From: Sarah Burrow
Sent: 03 December 2025 12:16
To: Planning.Responses
Cc: Hebe Smith
Subject: FW: FAO Sarah Burrow - Fwd: RE: FAO Kevin Macknay - Snetterton, West Walberton Lane, Walberton, West Sussex. BN18 0QS - SURFACE WATER DRAINAGE WA/33/23/DOC

Subject:RE: FAO Kevin Macknay - Snetterton, West Walberton Lane, Walberton, West Sussex. BN18 0QS - SURFACE WATER DRAINAGE WA/33/23/DOC

Your current drawing, submitted to ADC, shows your proposed connection being made into the existing road gully connection, this is not what was shown on your original drawing.

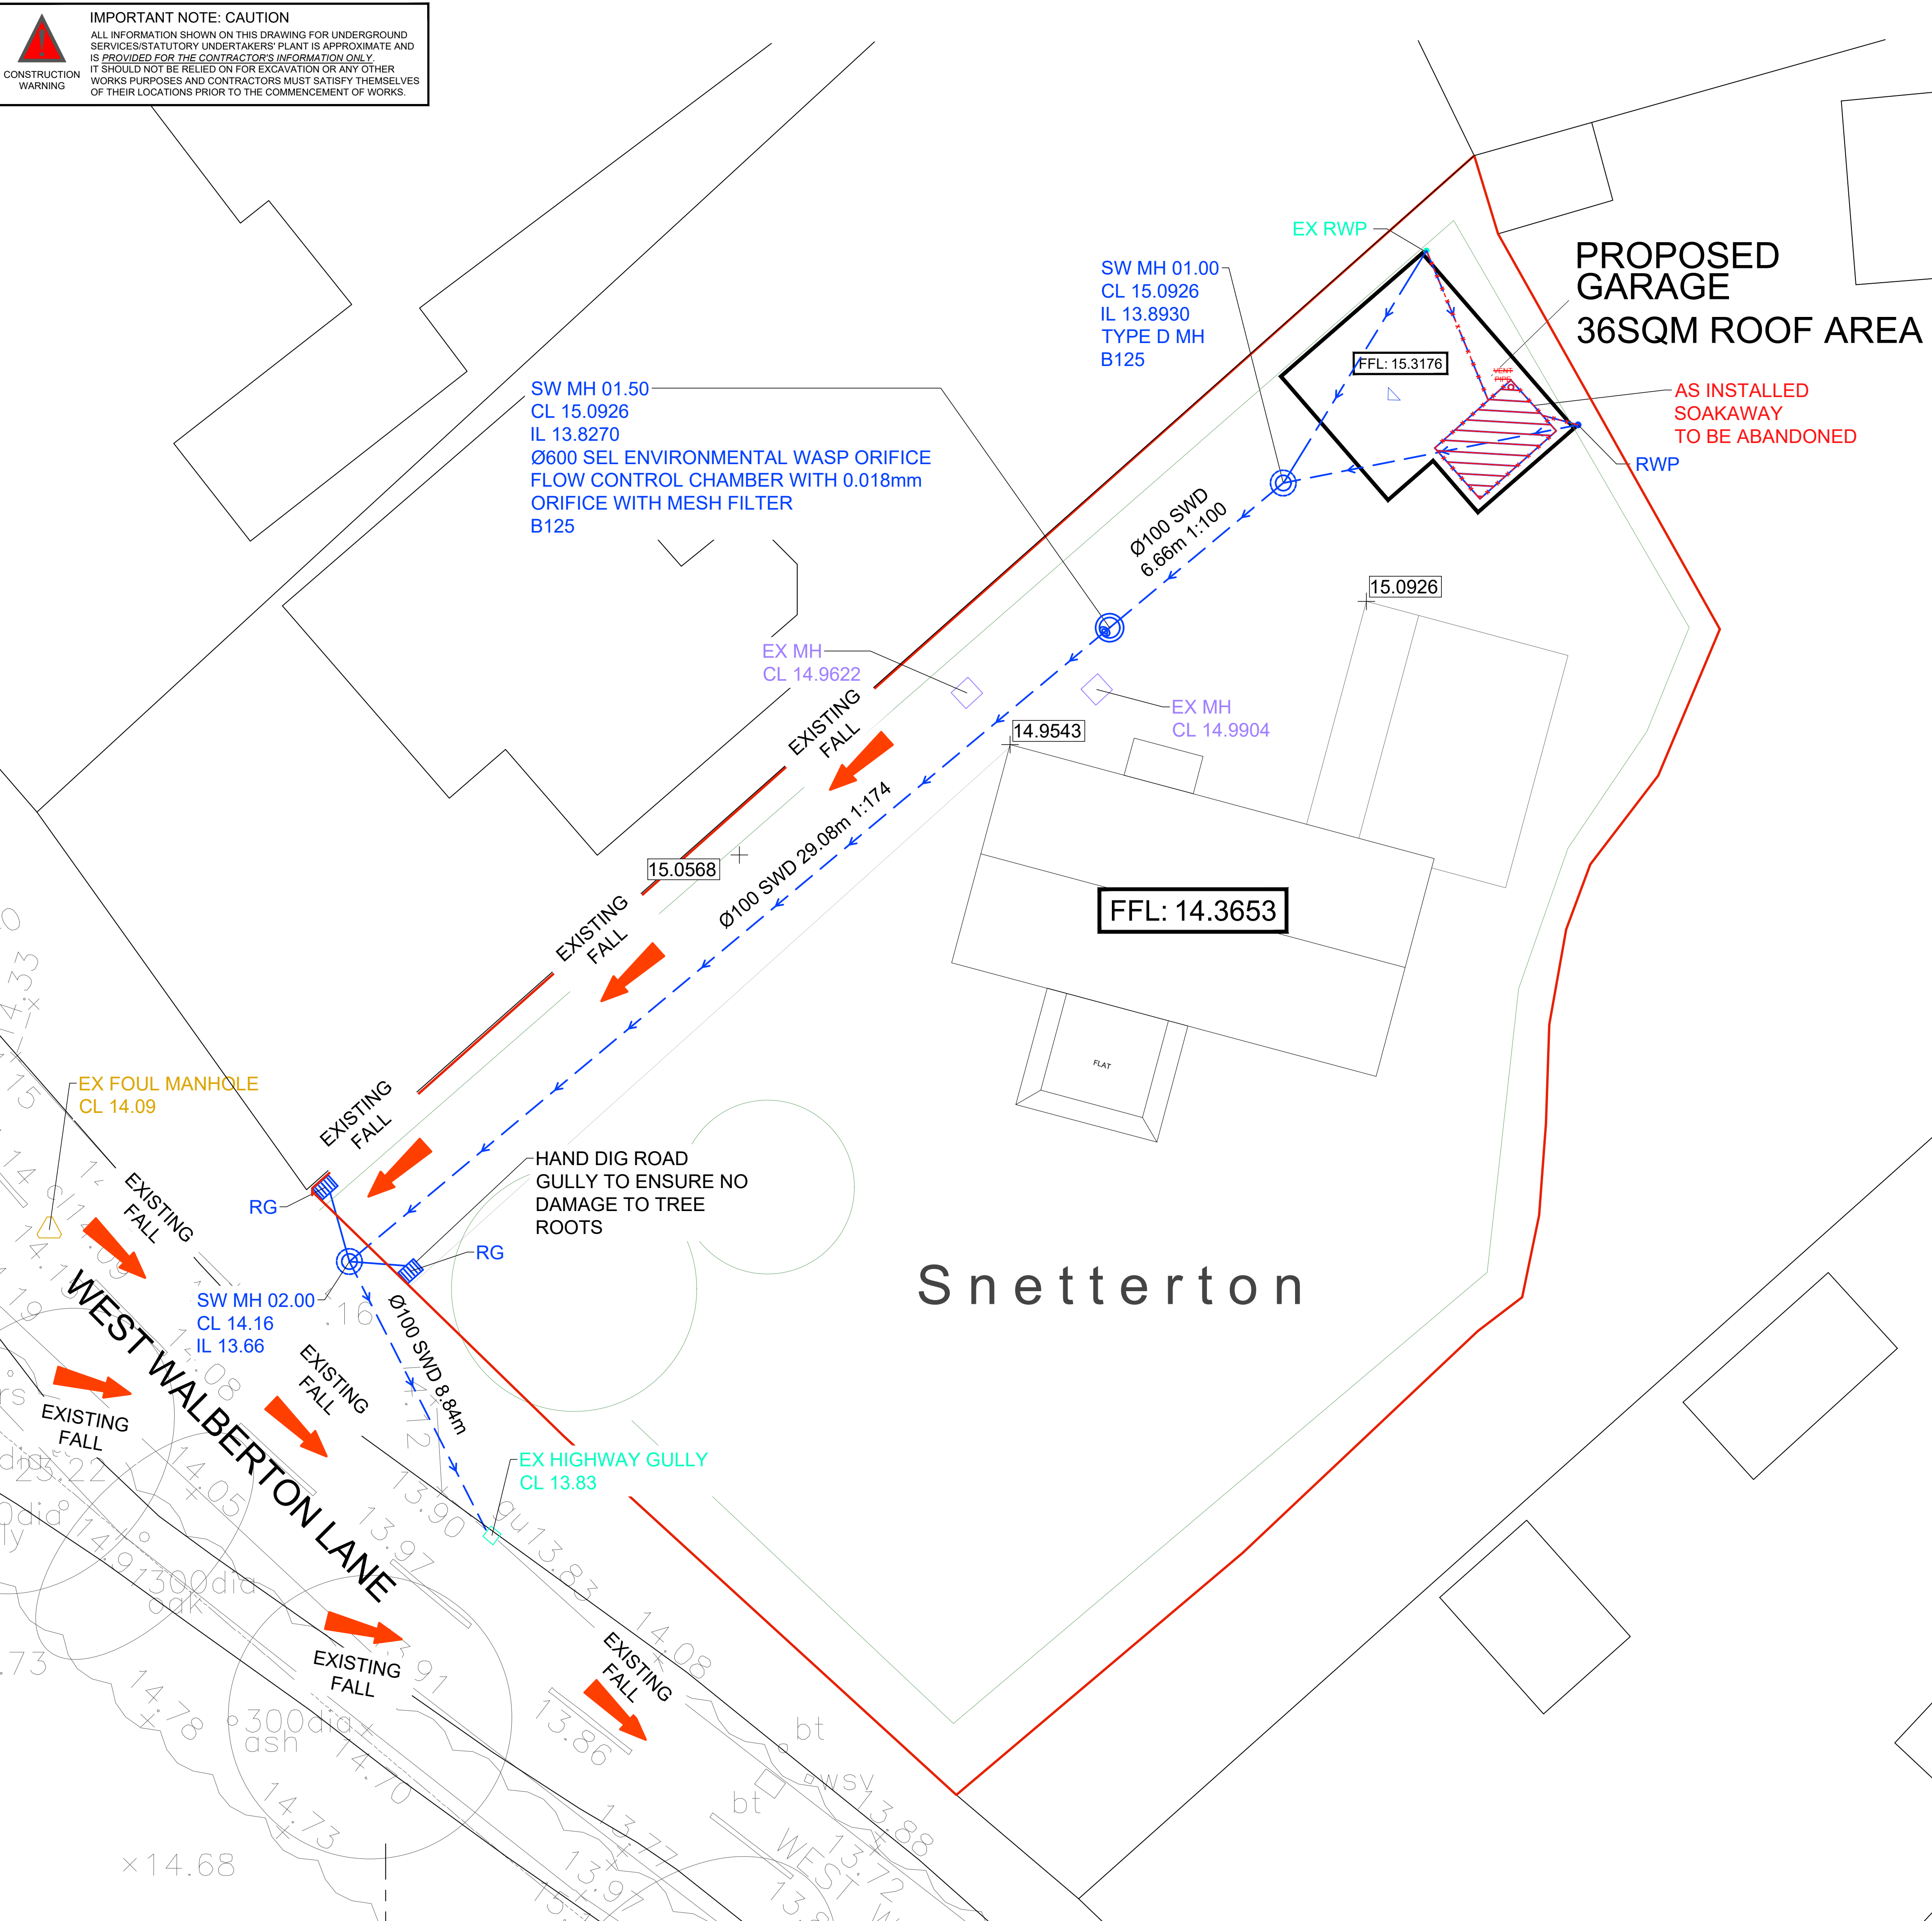
Your connection should be made direct into the gully, which should be reconstructed as a new catchpit gully to accept the connection.

For your information, I have attached details that show our standard detail for a catchpit gully (Type RG2, WSCC-SD1-0500-025).
